City of Portland, Maine - Building or Use Permit Application

Past Use: 46 unit condominium project	Proposed Use: Construct 4 unit building: Units 19, 20, 21, 22 of 46 unit project	Permit Fee: \$4,371.00	Cost of Work: \$450,000.00	CEO District: 4	FH
--	---	---------------------------	-------------------------------	--------------------	----

OCEAN RIDGE CONDOMINIUMS (UNITS 19-22)
852 OCEAN AVE, PORTLAND, ME.

To: John & Joseph Leasure From: Mike Nugent
Fax: 799-5432 Date: May 1, 2003
Phone: 767-4830 Pages: 1
Re: Ocean Ridge units 1,2,3 & 4

**A4**

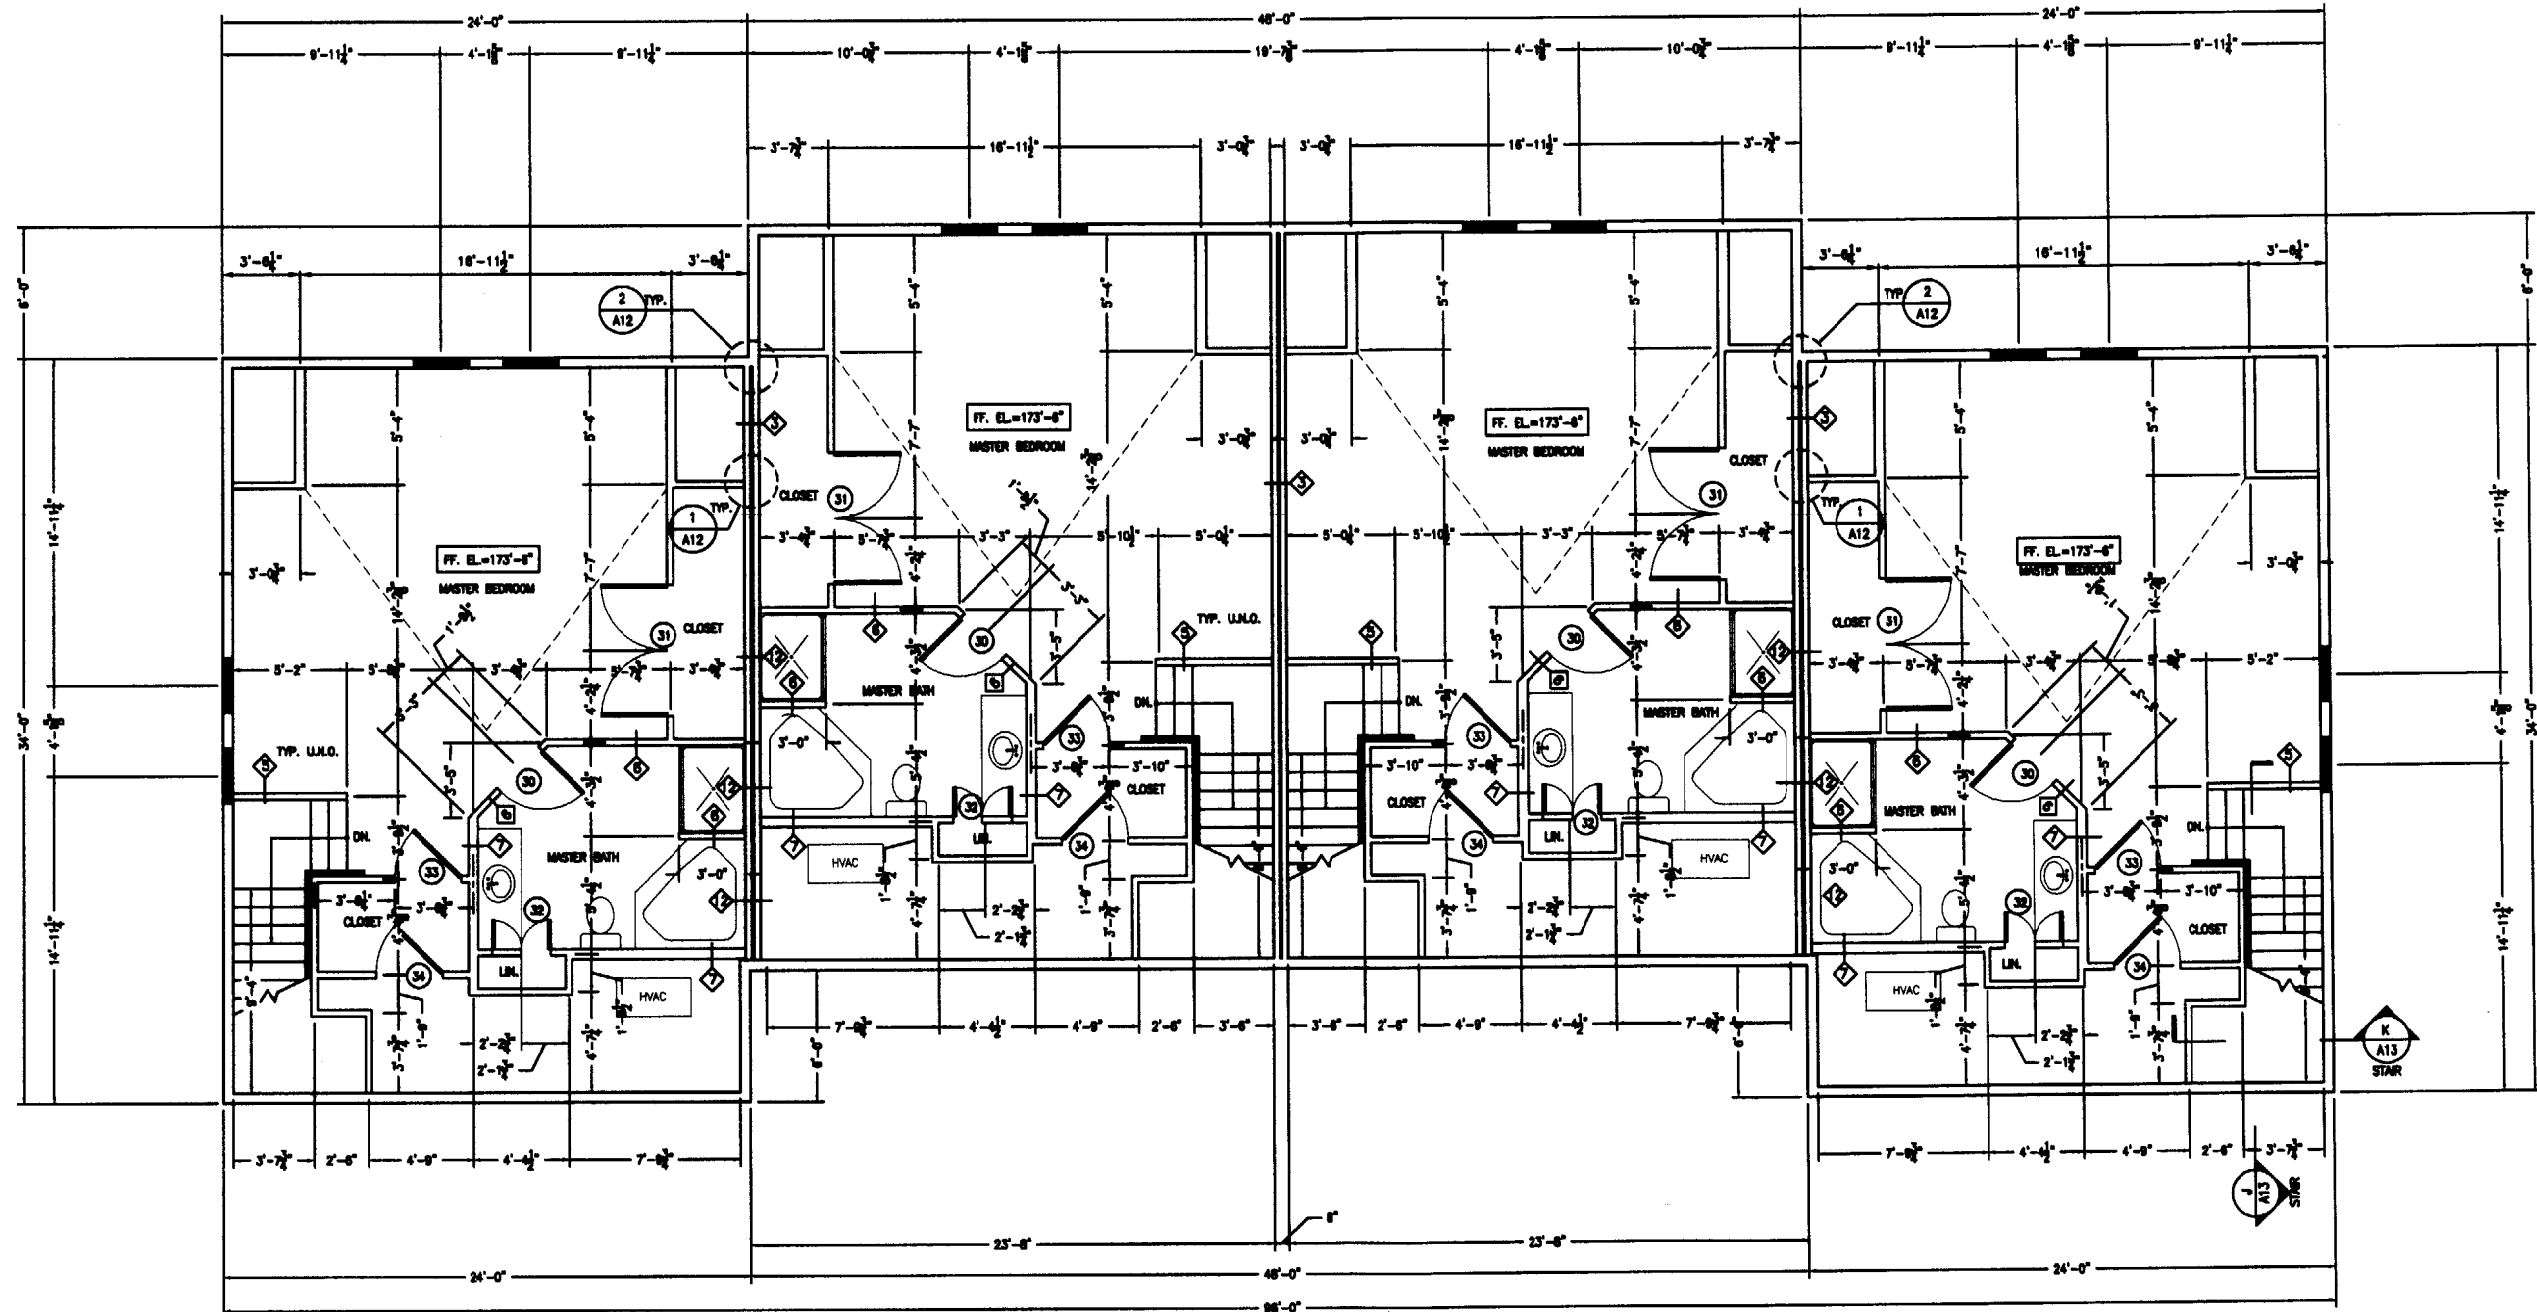
- 6) The space between the third floor ceiling joists and rafters exceeds 30 inches and no attic access is shown.
 - 7) The roof system must have a one-hour fire rating in 5A buildings.

- 6) Will provide minimum 22" x 30" opening access into the attic space. One in each dwelling unit third floor level. (BOCA 1999 Sec. 1211.2) See Dwg A4.

A9

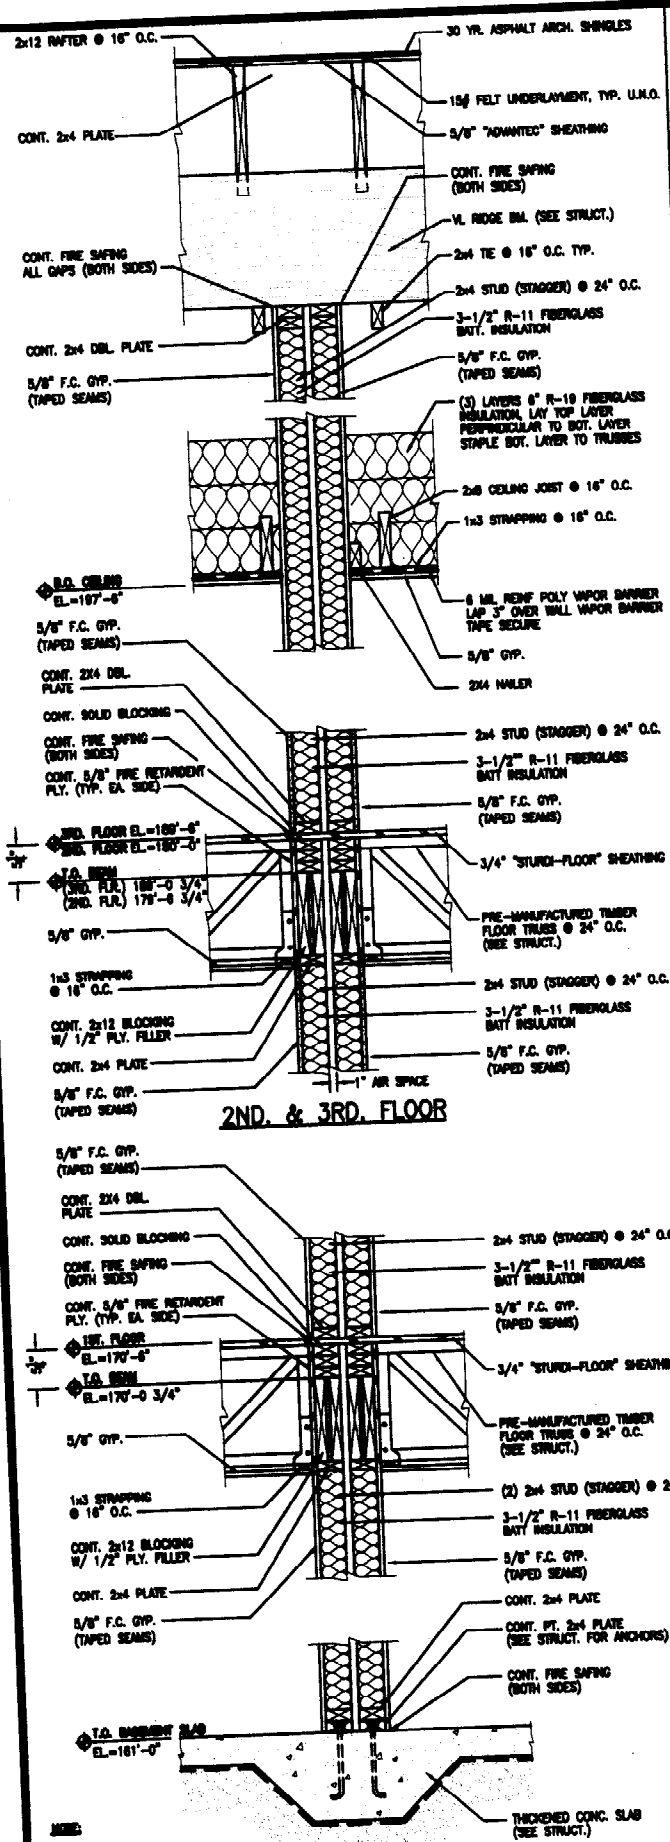
- 8) It appears that the floor ceiling assemblies need fire blocking as the space exceeds 500 Sq.ft.
 - 9) Does the wall system extend to the underside of the roof sheathing?

- 9) The Fire Rated Wall systems extends to the underside of the exterior roof sheathing typically as shown on Details 1 /A9 & Detail A/A10.
- 10) The STC of the Rated Fire Wall as shown on drawing A10 is 50-55. The other walls are between 30-35 depending on insulation and sheathing materials. If you need specific wall STC documentation, please contact this office.

- 11) The 1 Hour Fire Rated dwelling Unit demising walls extend continuous (including the fire retardant plywood) up to the underside of roof sheathing/ridge beam as indicated on drawings A9 & A10. The 5/8" gyp board on the ceilings between floors of the same dwelling unit is not part of the wall fire rated wall system. (Refer to Construction Permit # 13047 by State Fire Marshal's Office.)

A10

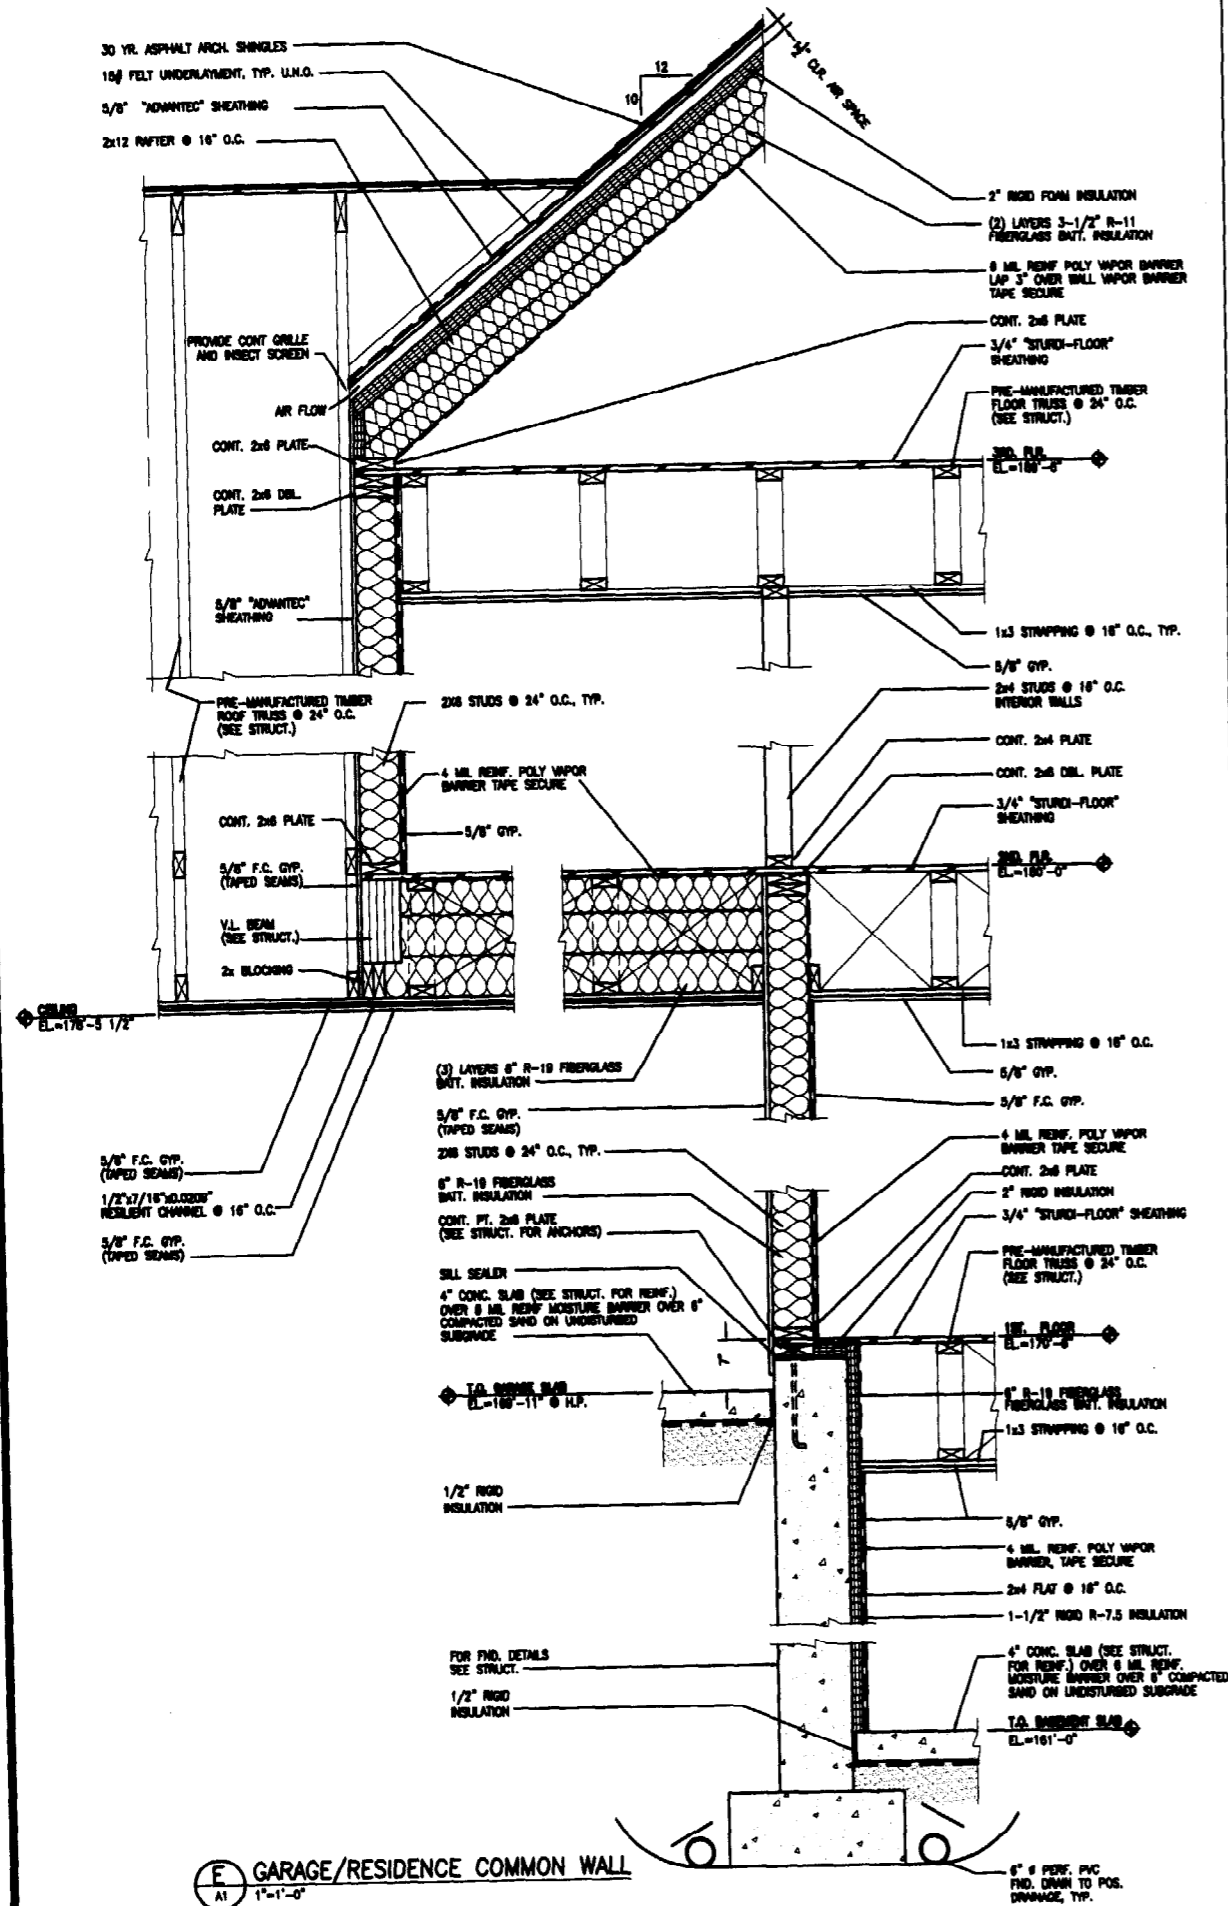
- 10) What is the STC of the wall assemblies?
 - 11) Page S9 Figure 5, using the FTW product, does the fire rated assembly include the GWB on the underside of the floor? (see section 711.4)
